Re: MODIFICATION TO KINGS FOREST APPROVAL NO. 08_0194 (MOD4)

Please find my submission re the proposed Modification to the Proposed Development at Kings Forest. I have significant concerns regarding this.

**FIGURE 17**

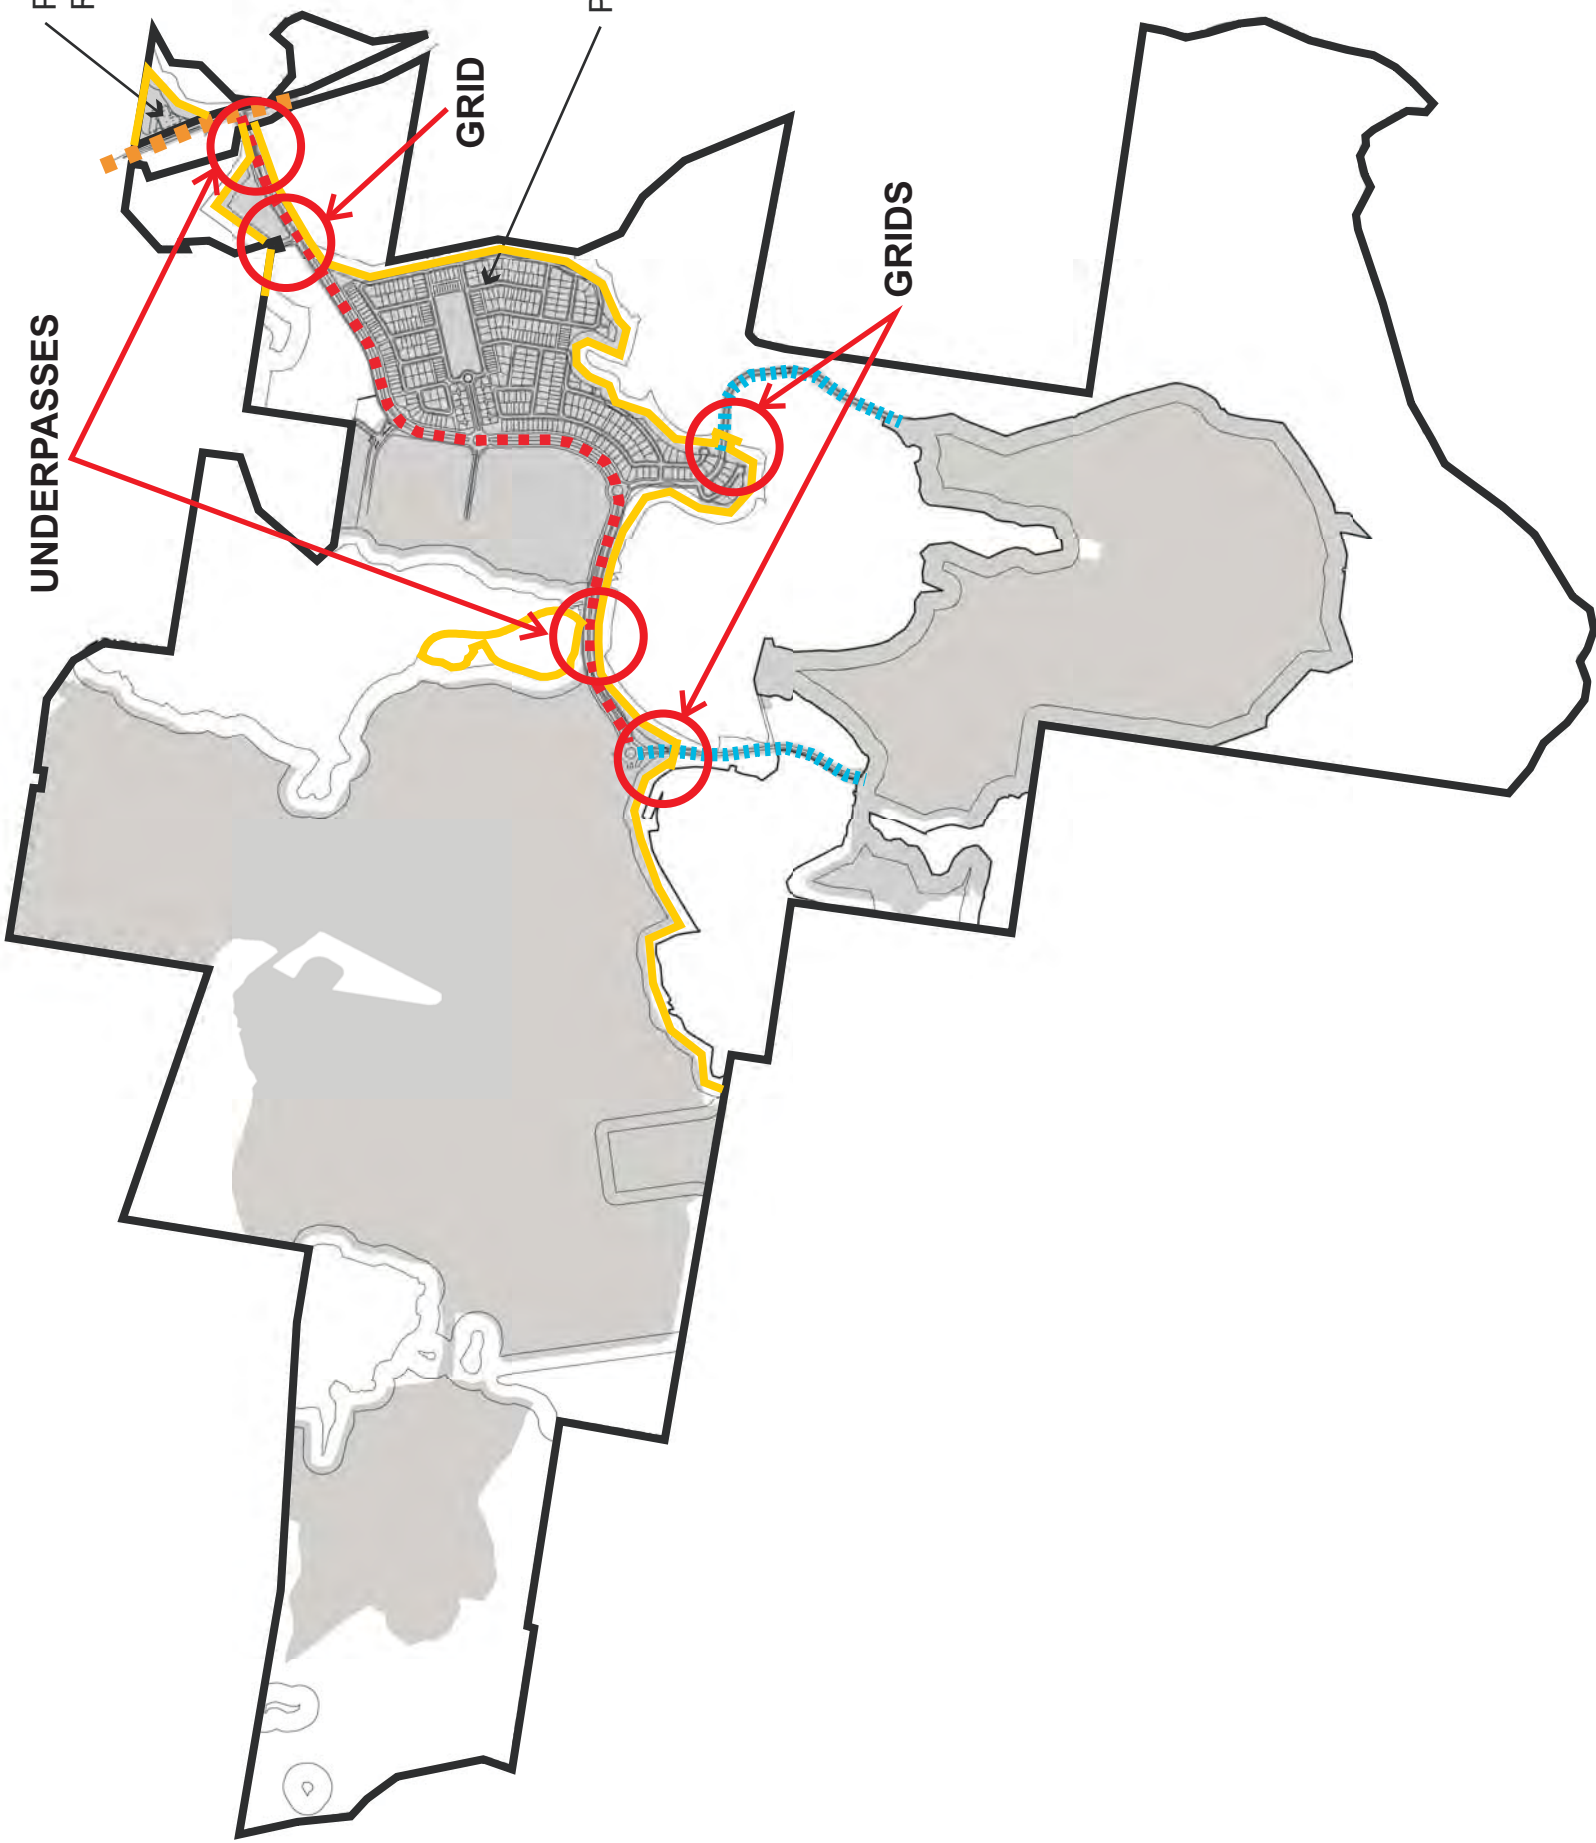
- a) I am concerned that maps in the revised KPoM indicate roads traversing major Environmental Areas with no fencing. This includes the P12-14 areas and also the additional E/W corridor. In both these areas where the road intersects the Environmental Areas the road needs to be fenced and a fauna underpass provided at that intersection.
- b) In addition, the Environmentally sensitive areas P12-14 should have fences around these areas. Similarly, the E/W corridor should have fencing on both sides of the corridor.
- c) The proposed use of cattle grids (areas P2 (Figure 30 & area P2-14 (fig 37) of the revised KPoM are a real concern and should not be used. There is no evidence that these devices will prevent ingress of dogs into Koala Habitat areas or vice versa stop Koalas moving into areas where dogs will have access. The proponent previously refused to make the

development dog & cat free, therefore they must put adequate controls in place to prevent ingress of dogs into Koala Habitat areas.

**FIGURE 20**

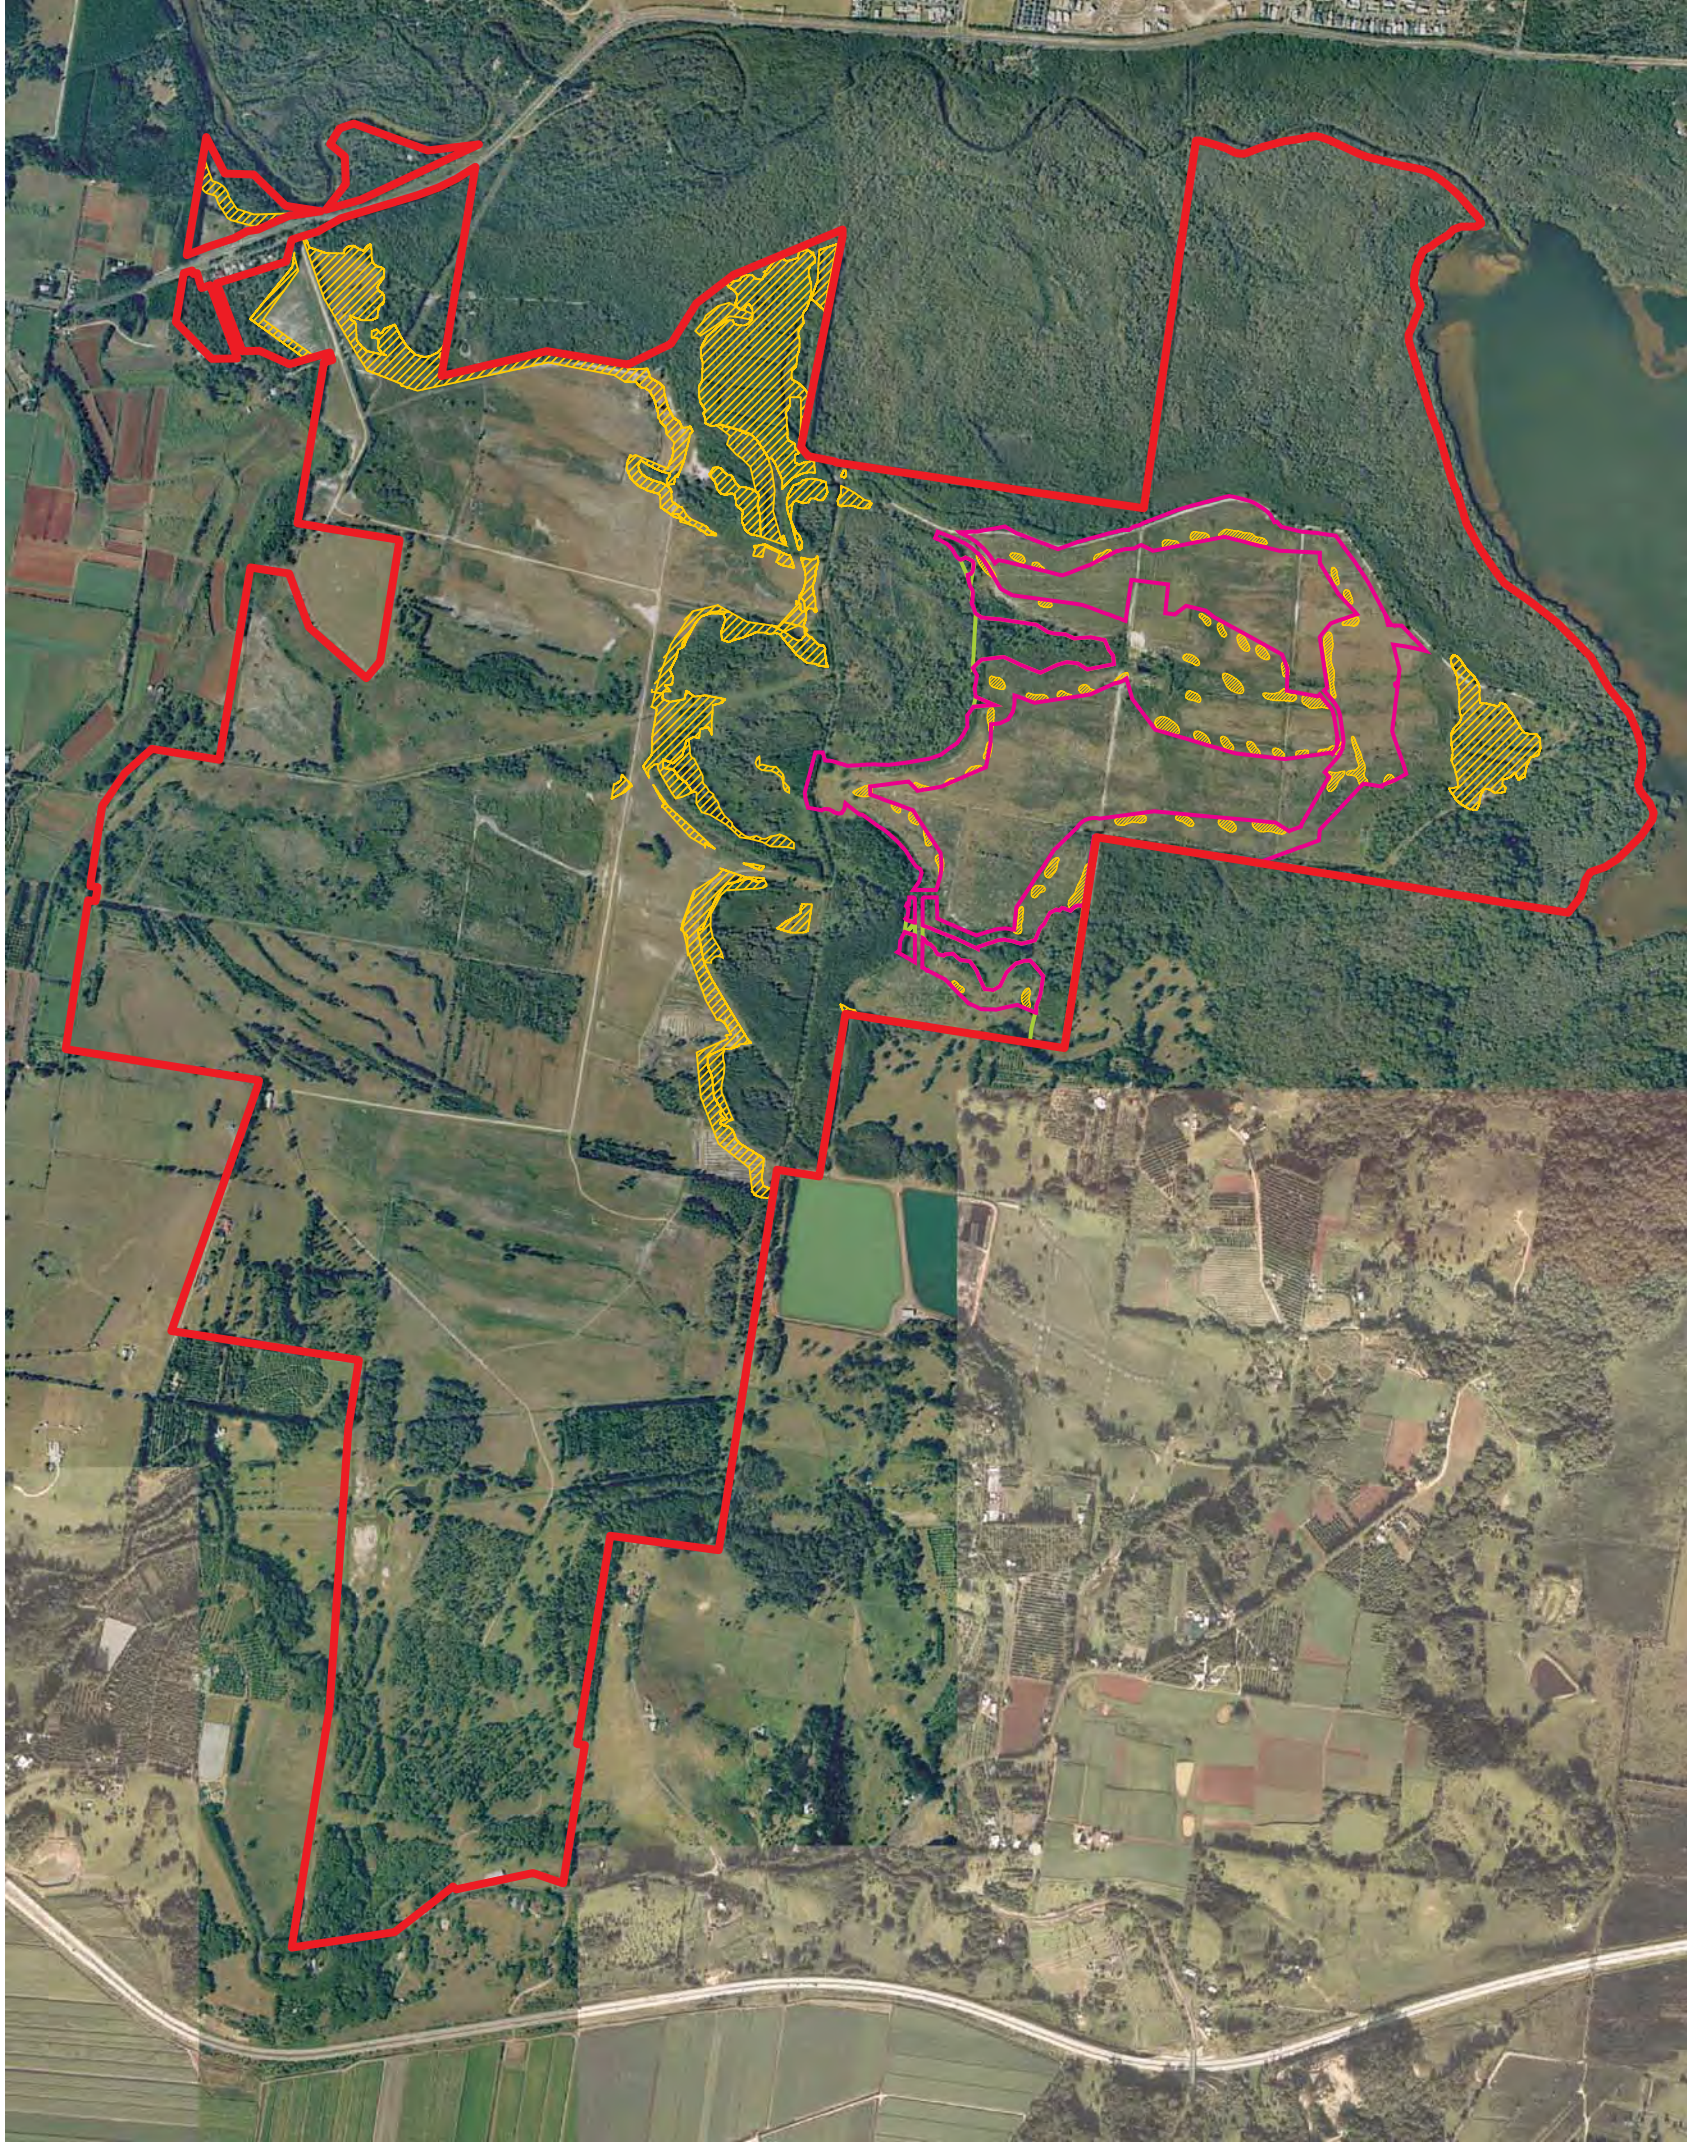
- b) Changing of the timing of koala tree planting in accordance with the revised KPoM. I am concerned that this proposal will greatly reduce the mature available Koala food trees when the development proceeds. I request that the existing requirement in the current condition be kept i.e. timing for the planting to occur within 1 month of the KPoM being approved. This is on the assumption the planting will occur well before the development proceeds. Ideally this should be a number of years in advance.
- c) Proposed changes to the areas of compensatory koala habitat planting to be per the revised KPoM 2017. This change proposed will reduce the area of habitat to be planted from 71.12 ha to 56.71 ha, this is a 20% reduction and hence should not be accepted by the DP&E. There should be nil decrease of Koala habitat planting that was earlier approved.
